Submission in Response the **Project (07_0155 Mod 2)** “Ardmore Park” Quarry via
Bungonia, NSW.

**The Committee of the Bungonia Times object to the proposed Modification
“Ardmore Park” Quarry Development .**

Figure 2: Principal proposed local haulage route

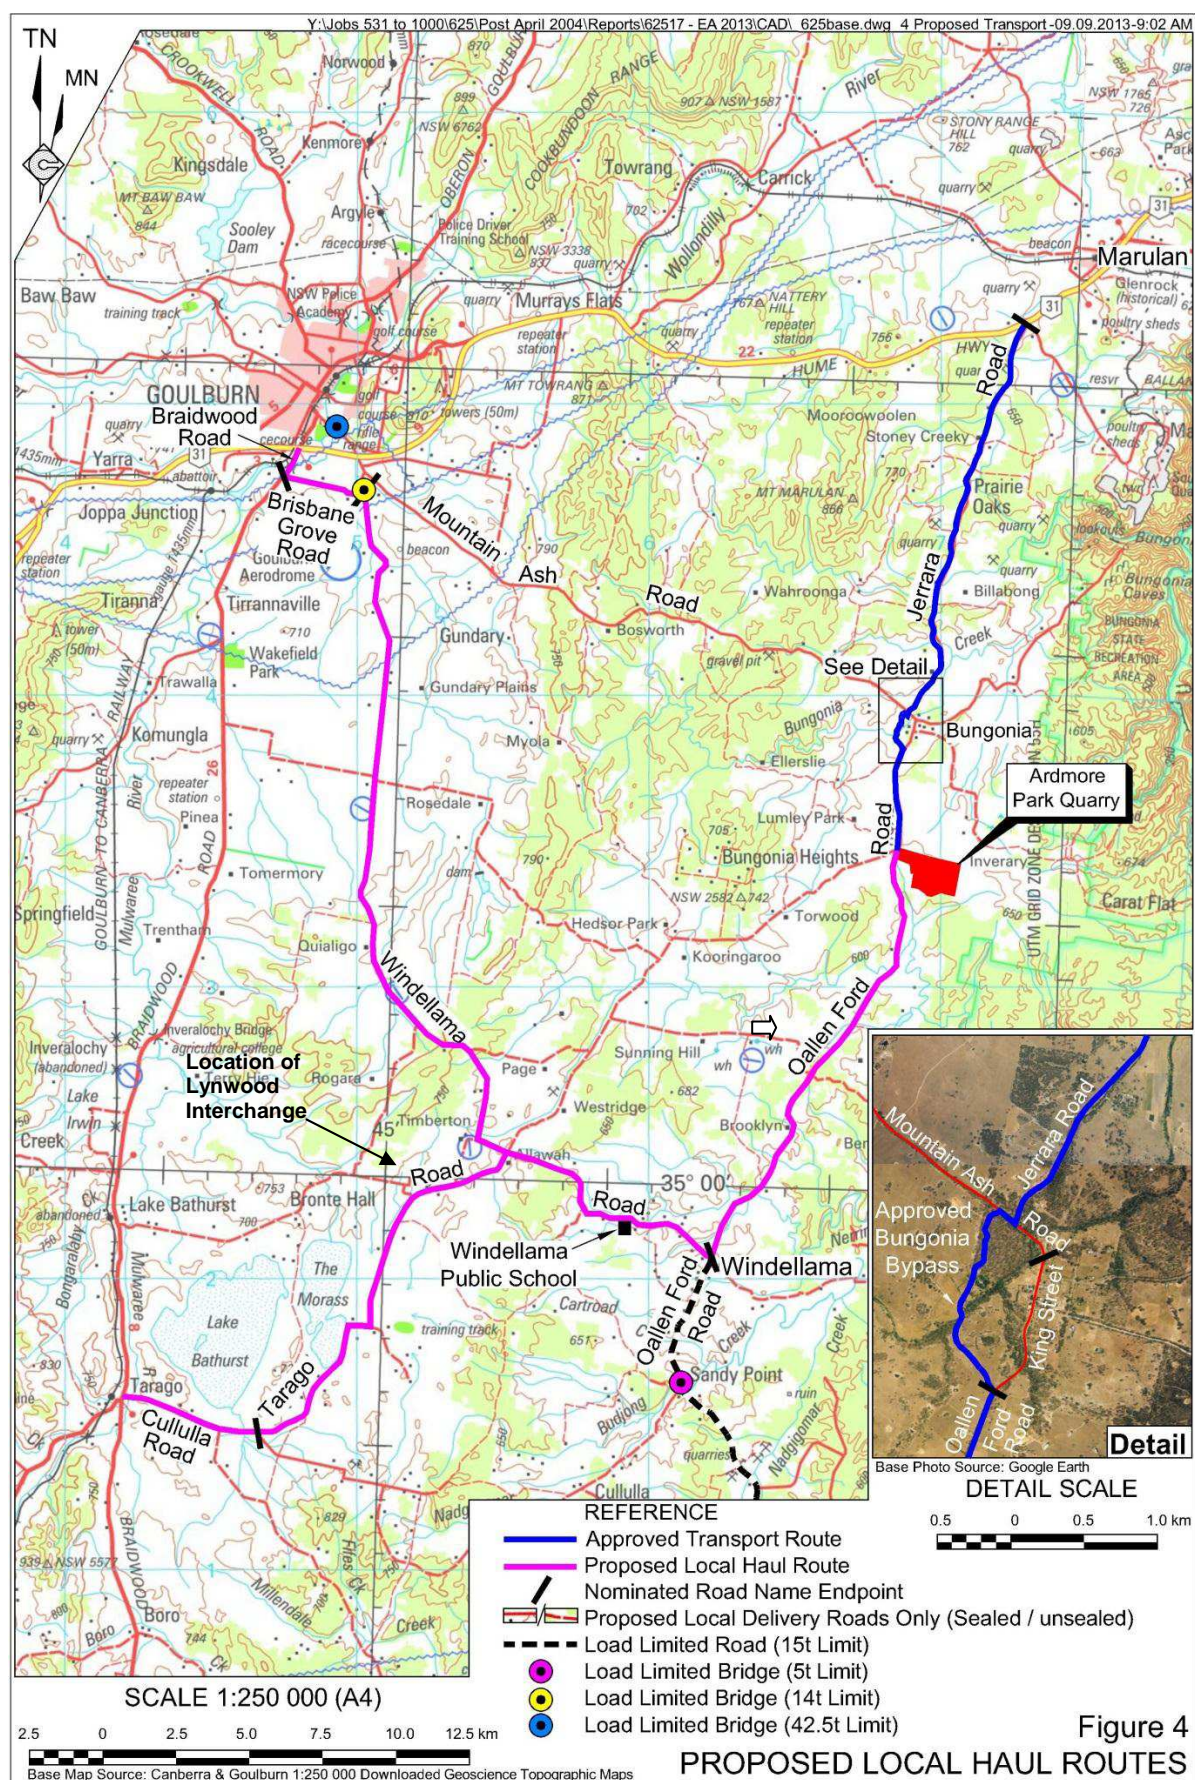
(which is considered as dangerous as narrow roads) and in many instances poor road surface. Lumley Rd. is not sealed and is narrow. The Environmental Assessment considers the section of Lumley Rd. from Oallen Ford Rd. to Windellama Rd. unsuitable and the road doesn't improve after Windellama Rd. **This section of Lumley Rd. is incorrectly labelled Tarago Rd in Figure 4 Page.8 On the same map Jerrara Rd is called Oallen Ford Rd.**
